Addendum No. 1

RE: Contract # C204737

Moore County (U-5815BA)

SR-2055 (N POPLAR ST) FROM ELM ST IN ABERDEEN TO 500' NORTH OF BLUES CROSSING LN IN SOUTHERN PINES

5/14/99

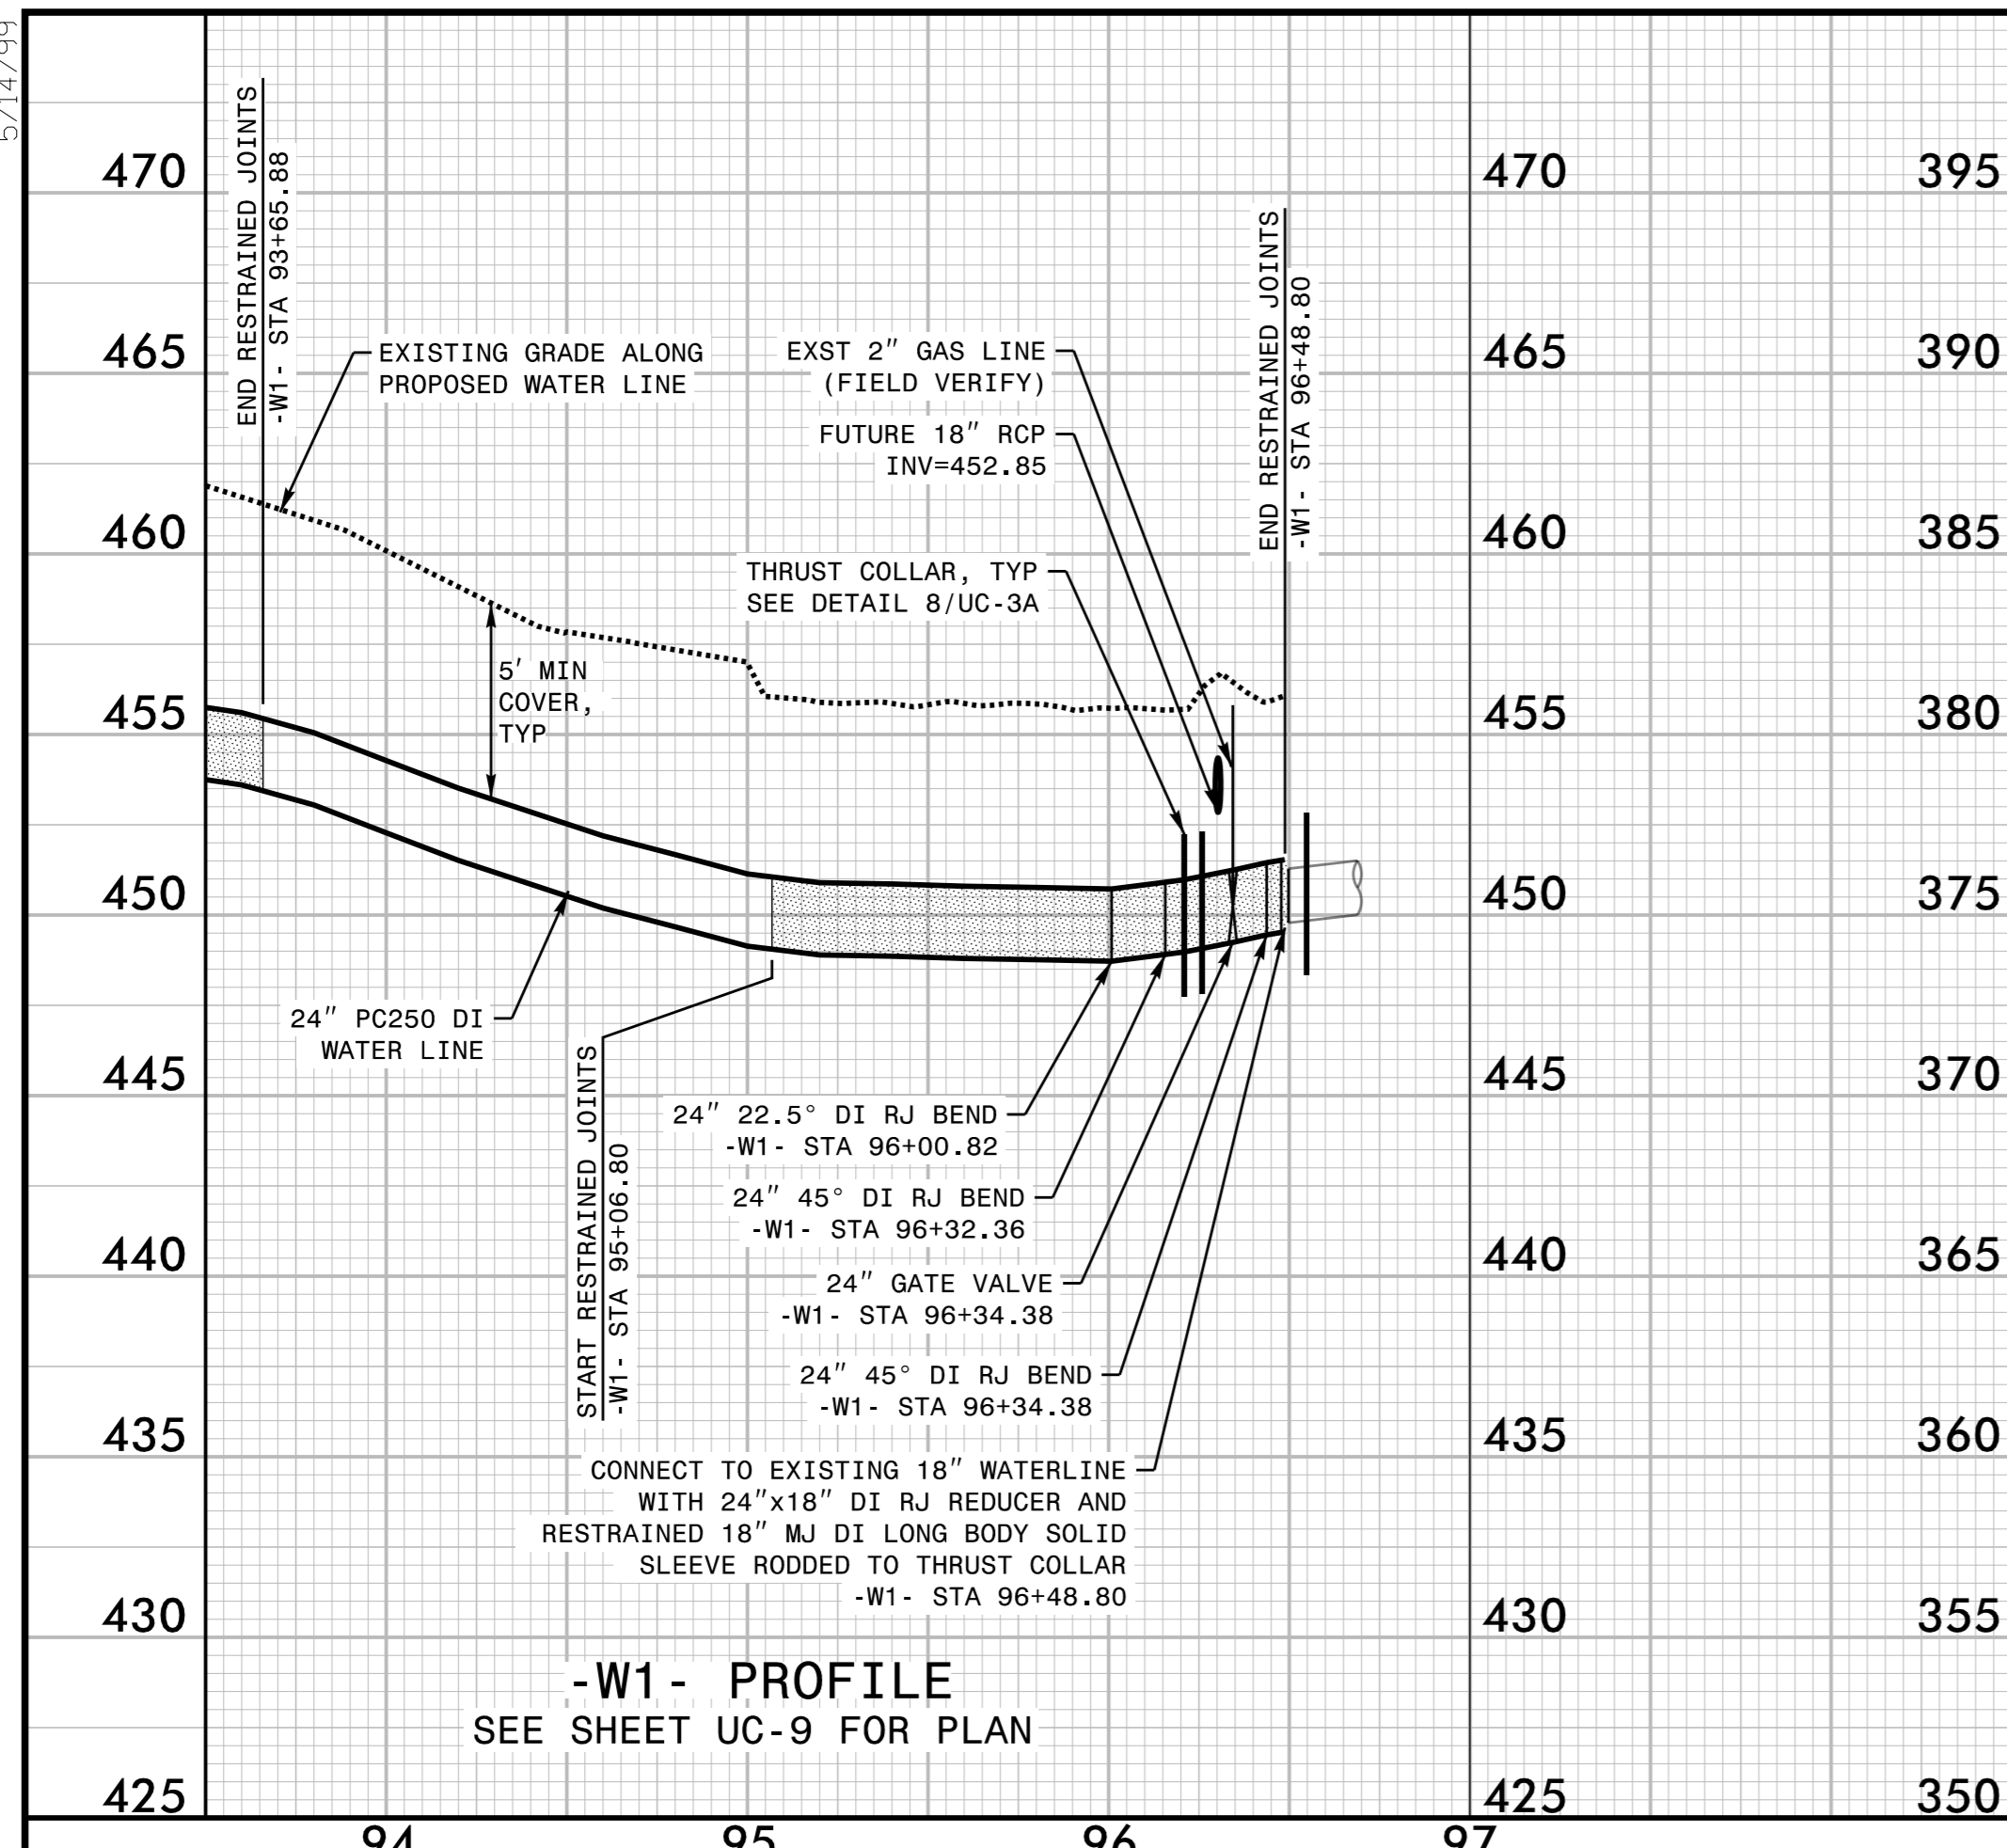
Sheet No.	Revision
UC-10 to UC-13	Revised vertical location of crossing gas lines shown on water line profiles based on test holes. Minor vertical adjustments to water line profiles to avoid conflicts with gas lines.
